Recommendation Report for Planning Permission for Works or Extension to a Dwelling

REF NO: P/21/21/HH

LOCATION: 6 The Green
Pagham
PO21 4RZ

PROPOSAL: Loft conversion to form new first floor with front and rear dormer projection

Proposed

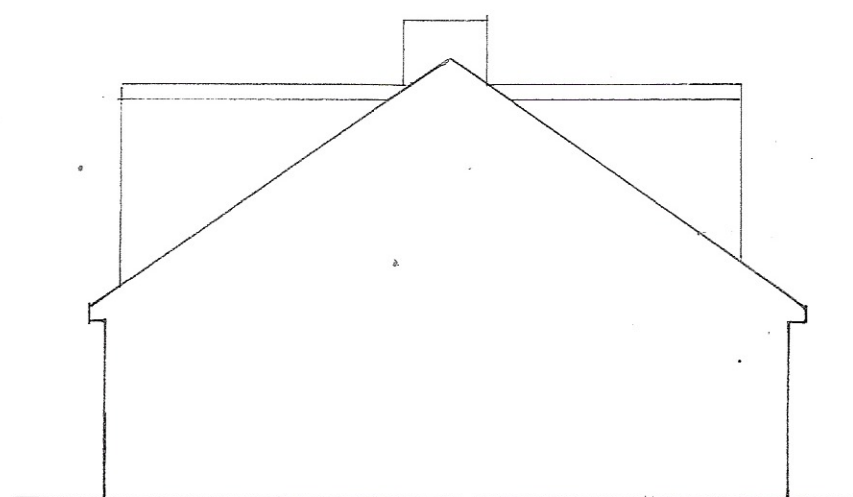
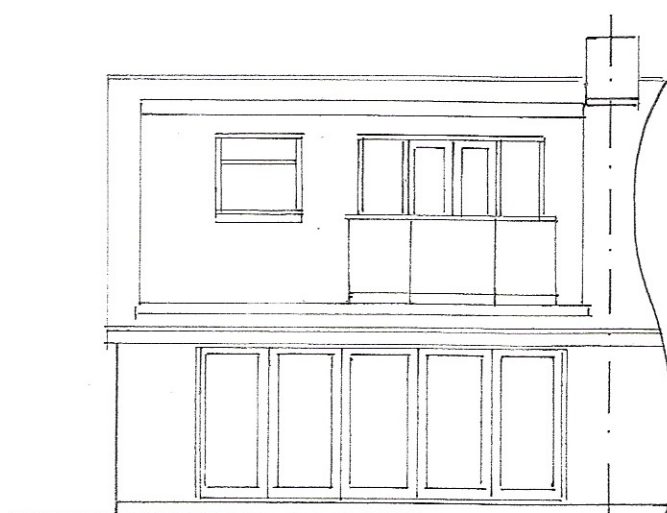
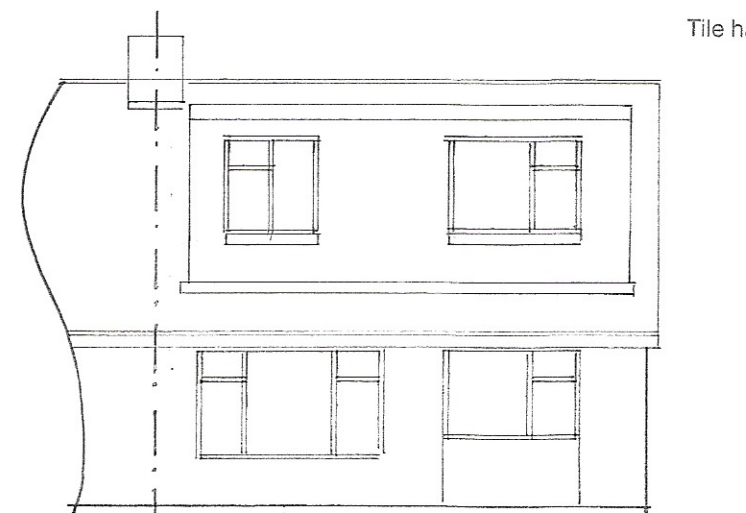
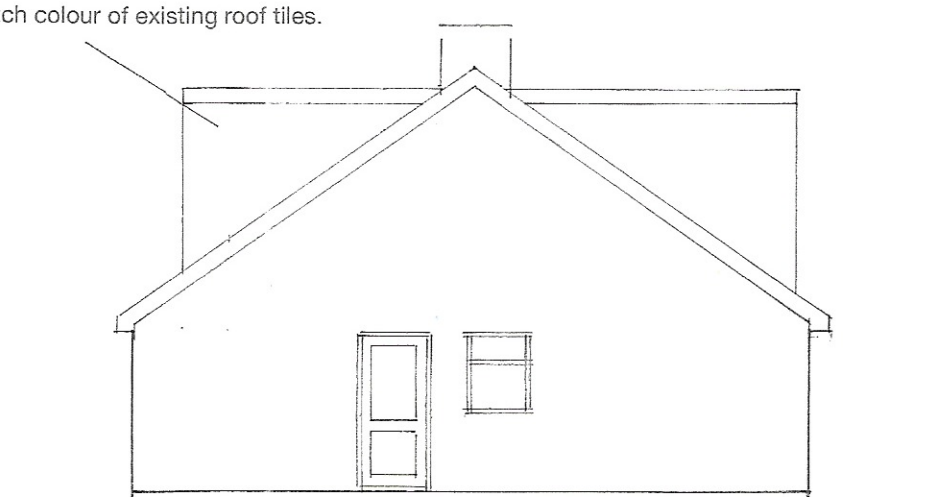
The proposal consists of the conversion of the roofspace to habitable accommodation with the construction of front and rear dormers. As a result of the siting, the works are highly visible from the street scene as there will be works to the front and rear.

Due to the location of the dormers, which extends beyond the roof line of the dwelling to the front of the site, it is not a subservient addition however is integrated with the dwelling and is proportionate in scale to that of the size of the dwelling.

The Arun Design Guide explains in section M that alterations to a dwelling should compliment the character and appearance of the building and wider landscape. With no other dwellings in the locality having dormers to the front the scheme is out of character with the area and obtrusive in form. As well as design guide specifies to the front of properties proposals should avoid large, flat topped alterations which this proposal does not have. Page 119 of the Arun Design Guide states:- "Alterations to the roof profile should not detract from the character and appearance of the dwelling or wider area in any case. This can be achieved through smaller scale dormer windows with pitched roofs which, when used in combination, tend to be more successful than single, large flat-roofed box-shaped dormers." The box dormer at the front fails to comply with this approach.

Due to siting of the proposal to the front of the property with it is highly visible from the street scene, it is considered to be detrimental to the appearance of the locality, and as such conflicts with D DM1 and D DM4 (a) and (e) of the Arun Local Plan.

The rear dormer has a flat roof. The flat dormer has a depth of 3.8m, with a height of 2.75m. To the front the proposed dormer measures 3.3m in depth with a height of 2.4m. Both dormers have a width of 5.9m.

The dormer to the rear has a proposed Juliette balcony this will be on the southern side of the proposal

and a further window on the rear elevation at the first floor. Whilst the neighbouring properties have extensions to the rear the proposal is at the first floor, as such it is considered to overlook the neighbouring property. The views into neighbouring properties could, in part, be restricted through the reasonable use of a condition to obscure glaze the window. The views from the dormer to the front would provide views over the street scene which are considered acceptable.

- 1 The dormer to the front by reason of its size, design and position is considered to be out of character with the area, by virtue of location and scale conflicting with policies D DM1 and D DM4 of the Arun Local Plan and the Arun Design Guide.
- 2 INFORMATIVE: Statement pursuant to Article 35 of the Town and Country Planning (Development Management Procedure)(England) Order 2015. The Local Planning Authority has acted positively and proactively in determining this application by identifying matters of concern with the proposal and determining the application within a timely manner, clearly
